Submission ID: 35873

# Aldington and Mersham Support Group Submission for Deadline 5 (15<sup>th</sup> April 2025)

Drawing Title
 INVERTER STATION
 ILLUSTRATIVE GENERAL ARRANGEMENT

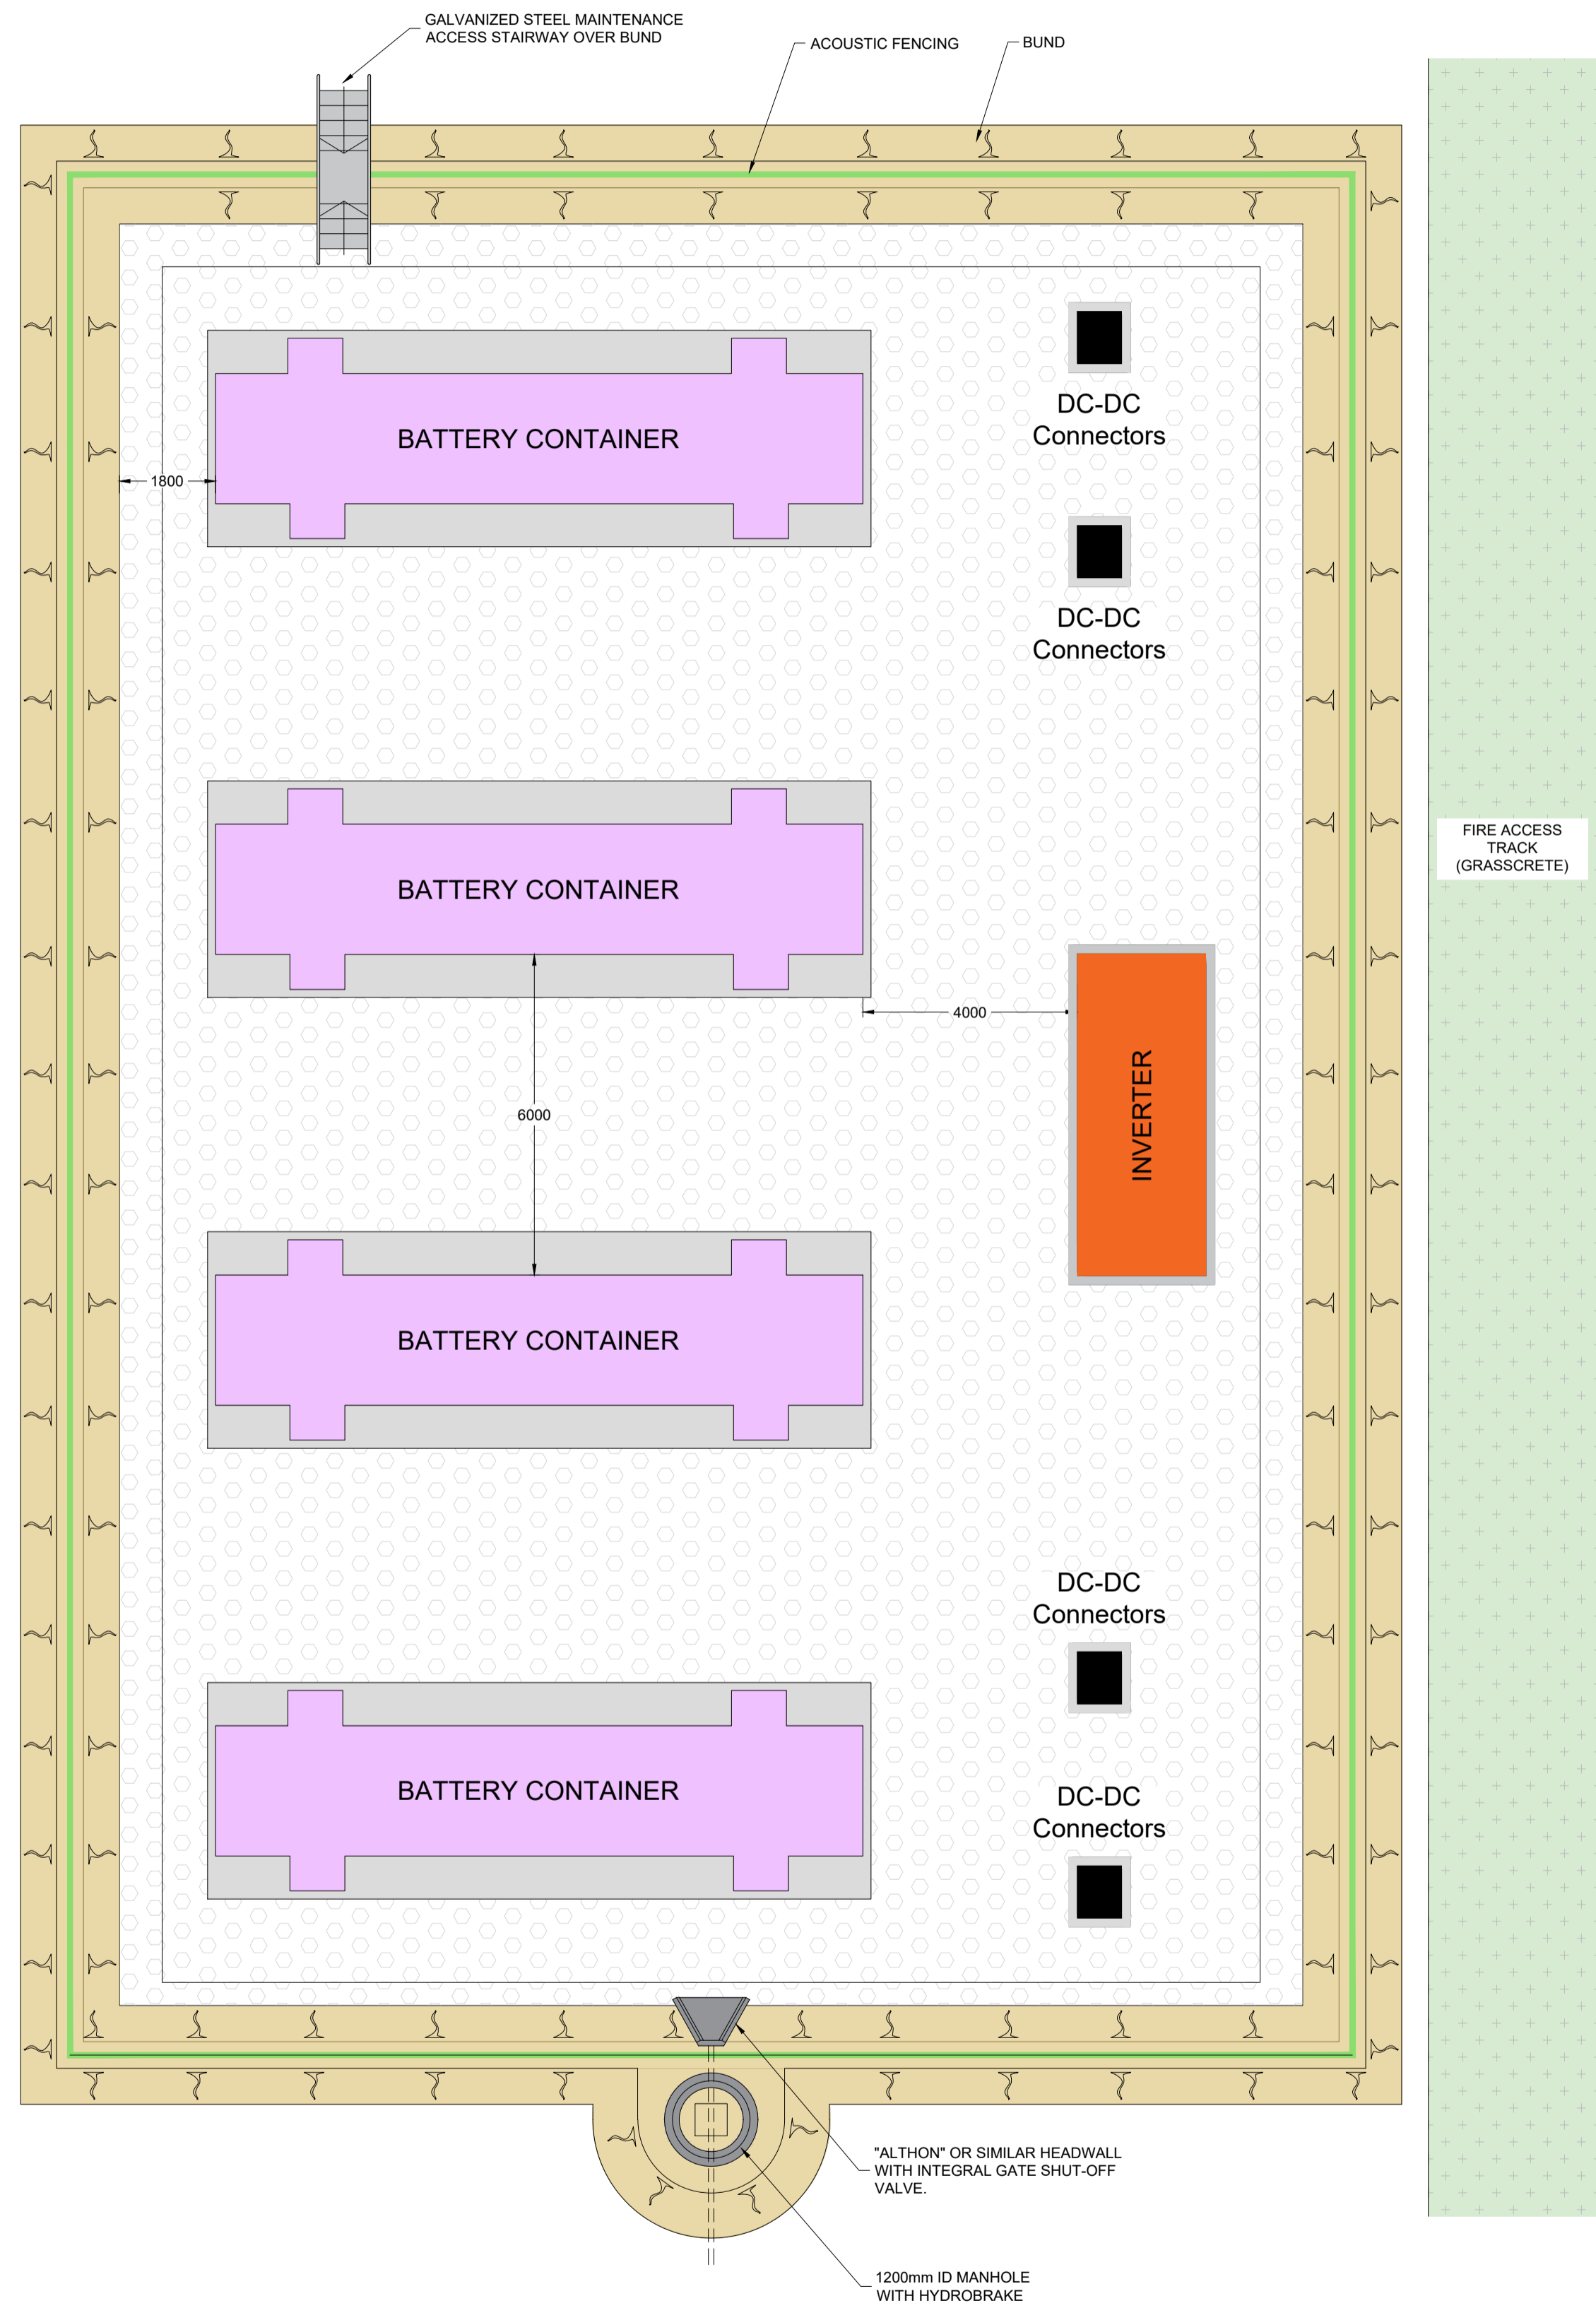
- Further to our submission for deadline 4, the failure of the KFRS representative and the Applicant's expert to attend ISH4 remains of significant concern to the community and we do not believe that all of the issues around battery safety have been adequately examined. We remain particularly concerned about the volumes of water available to cool a battery fire, the impact of toxic plumes on neighbouring residential properties and the volume of containment for contaminated fire water (**REP4-057 and REP4-037**).

- The NFCC guidance for fire and rescue services relating to Grid Scale Battery Energy Storage System Planning states that *"hydrant supplies for boundary cooling purposes ..... should be capable of delivering **no less** than 1,900 litres per minute for **at least 2** hours (emphasis ours). Fire and rescue services may wish to increase this requirement dependant on location and their ability to bring supplementary supplies to the site in a timely fashion"*. With reference to the Exa's Q8.04 (**PD-008**) regarding water capacity, it is evident that as demonstrated by the recent fire at Handen Farm, that there are limited supplies of water available from local hydrants and there is significant difficulty in transporting large volumes of water to the site. As a consequence, surely much larger volumes of water need to be stored on site. Given the NFCC guidance regarding supplementary supplies, we suggest that Q8.04 also be addressed to the Applicant.
